A303 Amesbury to Berwick Down Case Team 01.05.2019  
National Infrastructure Planning  
The Planning Inspectorate  
Temple Quay House Bristol BS1 6PN  
By email: [A303Stonehenge@planninginspectorate.gov.uk](mailto:A303Stonehenge@planninginspectorate.gov.uk)

**The Planning Act 2008 Section 89 and The Infrastructure Planning (Examination Procedure) Rules 2010 – Rule 8, 13 and 16**  
**Application by Highways England for an Order Granting Development Consent for the A303 Amesbury to Berwick Down**  
**Examination Timetable and procedure**

The following response relates solely to the impact on cycling of the proposed scheme and in particular the severance issues caused by the A303.

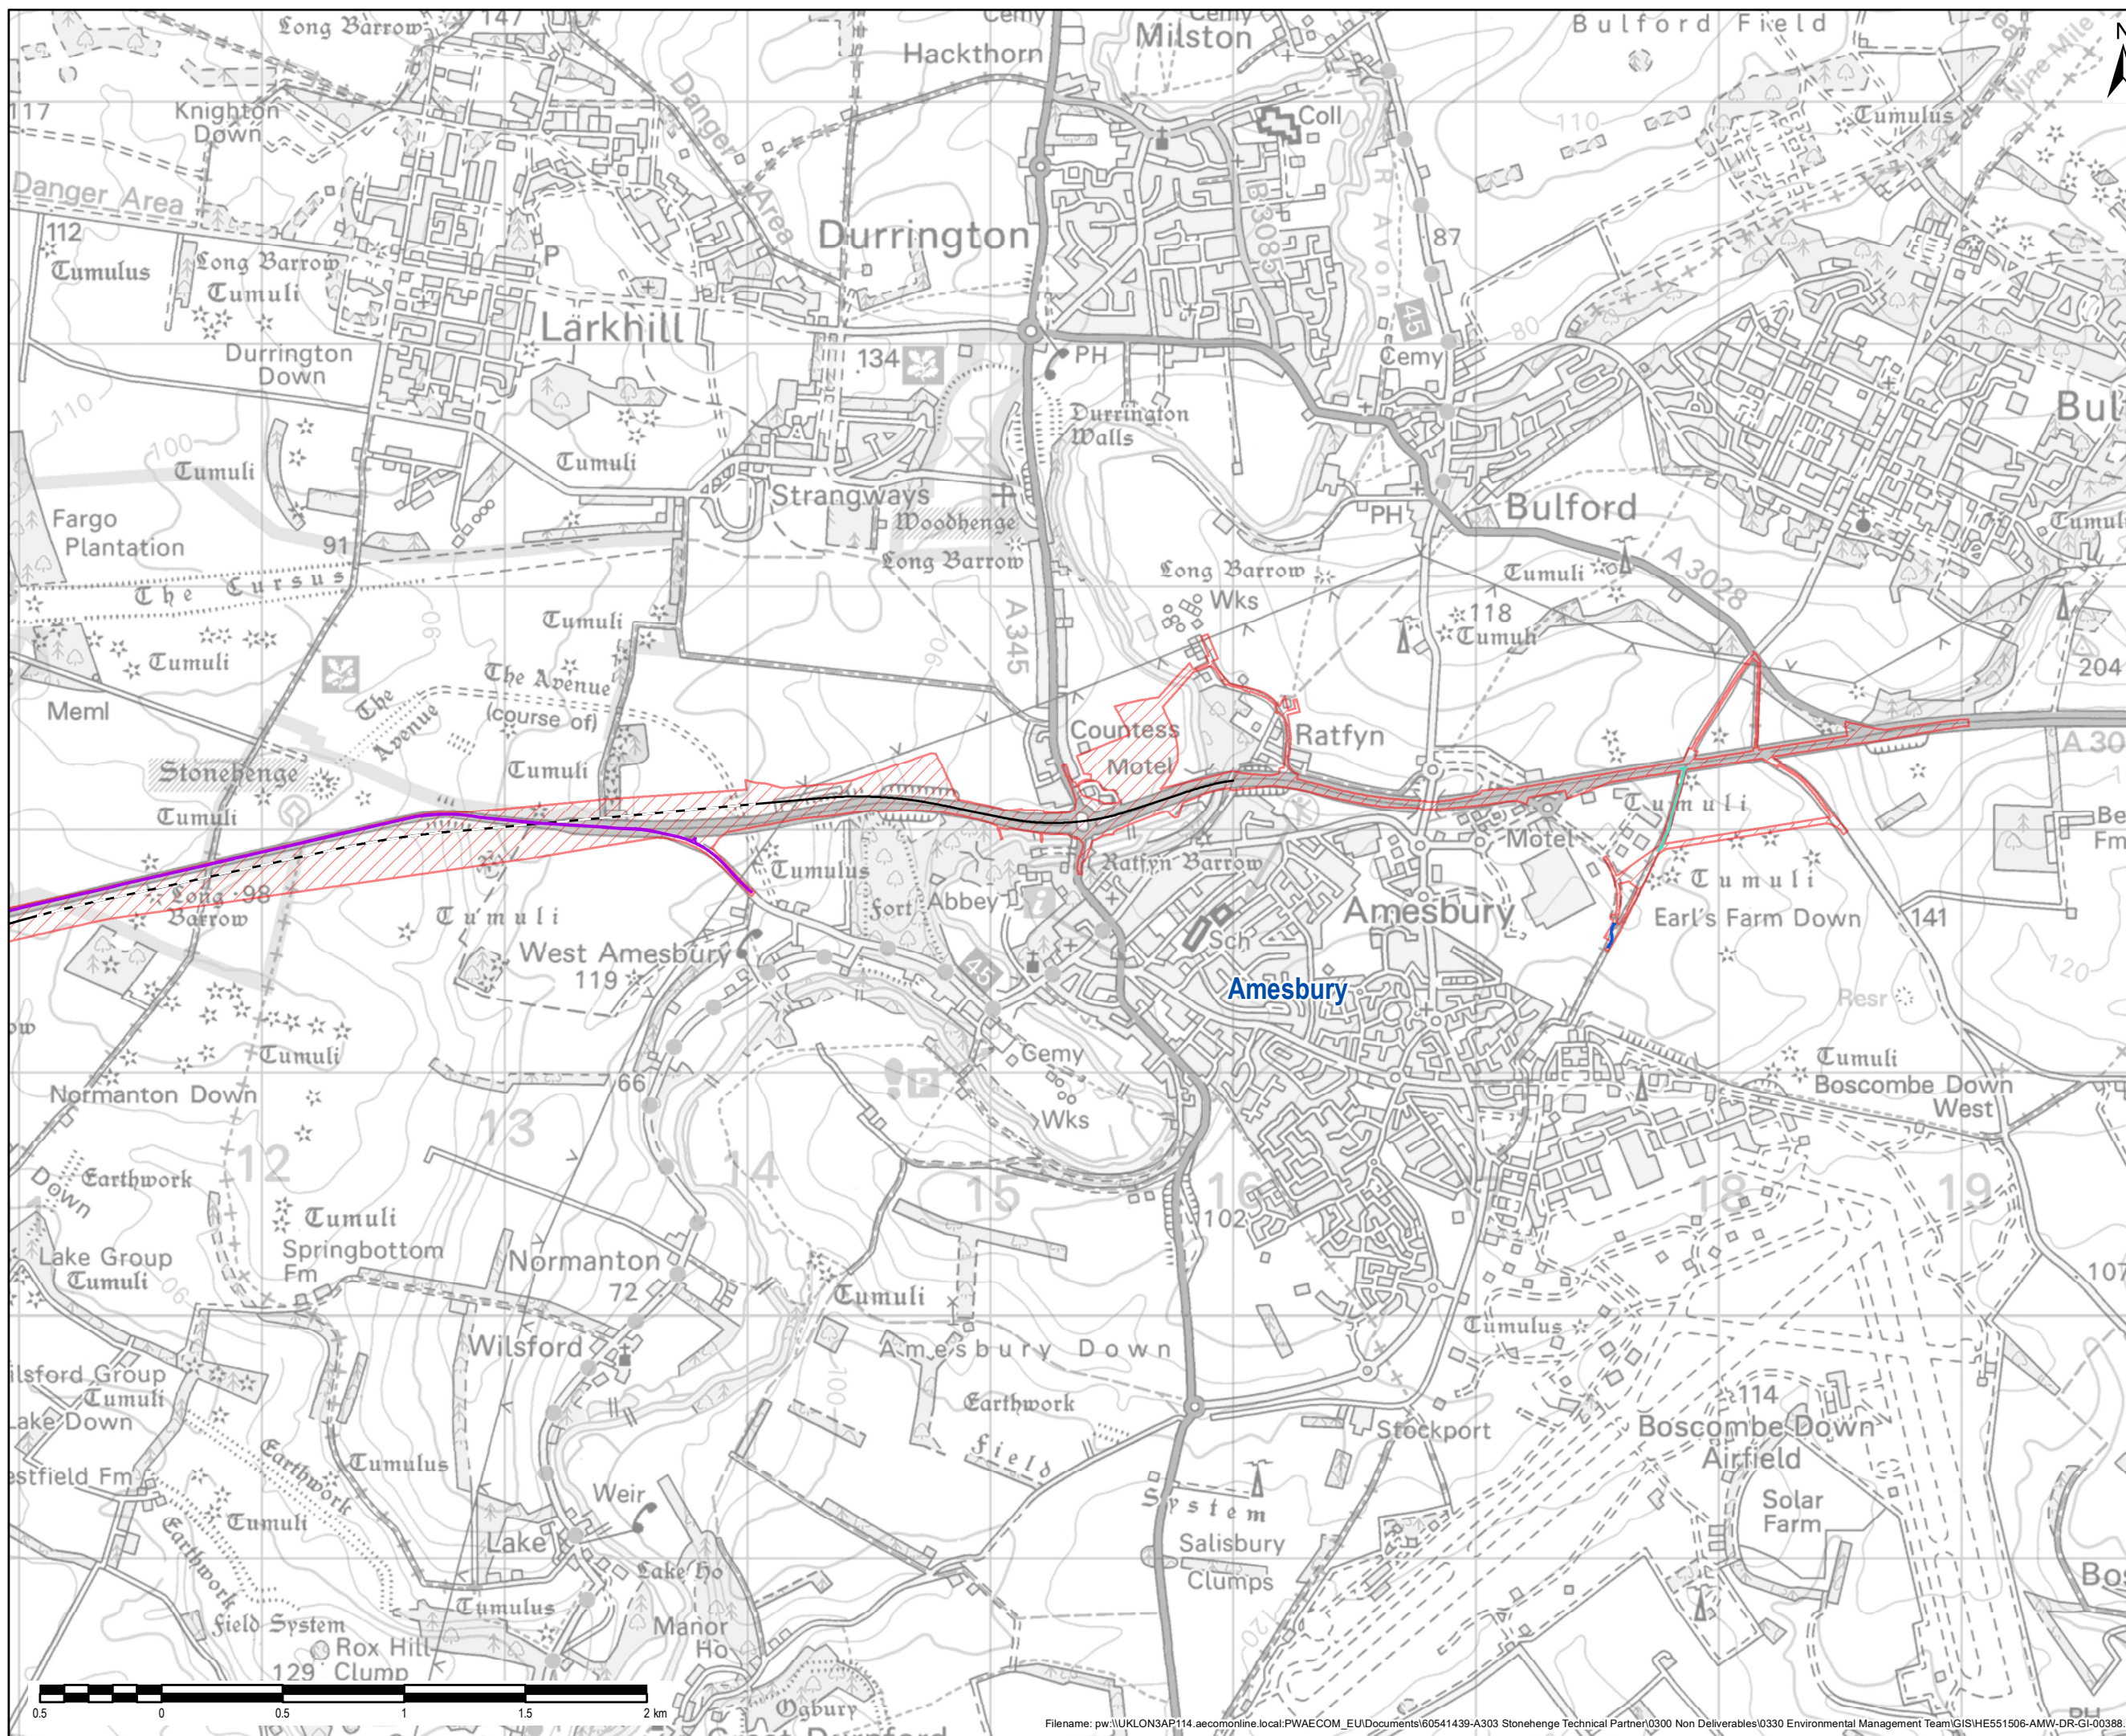
The proposed bridleway alongside and then south of the A303 from Winterbourne Stoke to Longbarrow junction should be suitable for commuting cyclists. If the width is inadequate for differential surfacing, the surfacing should be suitable for all NMUs and we suggest a material such as Flexipave (see <http://www.kbiuk.co.uk/>), which is acceptable for walkers, cyclists and equestrians.

We strongly support the provision of a restricted byway (RB) from Longbarrow Junction north to Airmen's Corner. This is essential to allow cyclists to access the road to Shrewton at Airmen's Corner. In particular we note the objection by English Heritage to this RB. We refer here to the experience gained from the stopping up of the A344 which exacerbated the existing severance for cyclists in this area. The exclusion of this RB from the scheme would be a major blow to sustainable transport and would be contrary to Highways England own cycling strategy. The proposed width of this RB is 4m and so we suggest a material such as Flexipave that can safely accommodate all NMUs. The detailed design of the route for accessing the proposed RB from the south and north should be safe and convenient.

On the alignment of the former A303, we strongly support the provision of an 8m wide RB consisting of:

- a 4m high quality bound low maintenance surface for cyclists, the mobility impaired and authorised motorised access, and
- a 4m wide chalk grassland habitat for pedestrians and horse riders.

We agree with the proposal to provide a suitably coloured surface for the bound section through the WHS. The bound surface should facilitate effective drainage which will also minimise ice build-

up and enable every type of cyclists to cycle at the recommended design speed for utility routes. The Amesbury end of the RB should flow into the existing Stonehenge Road.

We note that the section of the road to be stopped up between the new 'link' Allington road and the A303 will remain open for authorised access. We urge that this section is also kept available to cyclists and pedestrians travelling to and from the Cholderton Road, including Stonehenge YH – see additional comments below.

If such a route were provided, we would not object to the stopping up of the section of Allington Road from the A303 to the new road. If it is not provided, we object to the stopping up of that section of road to NMU traffic.
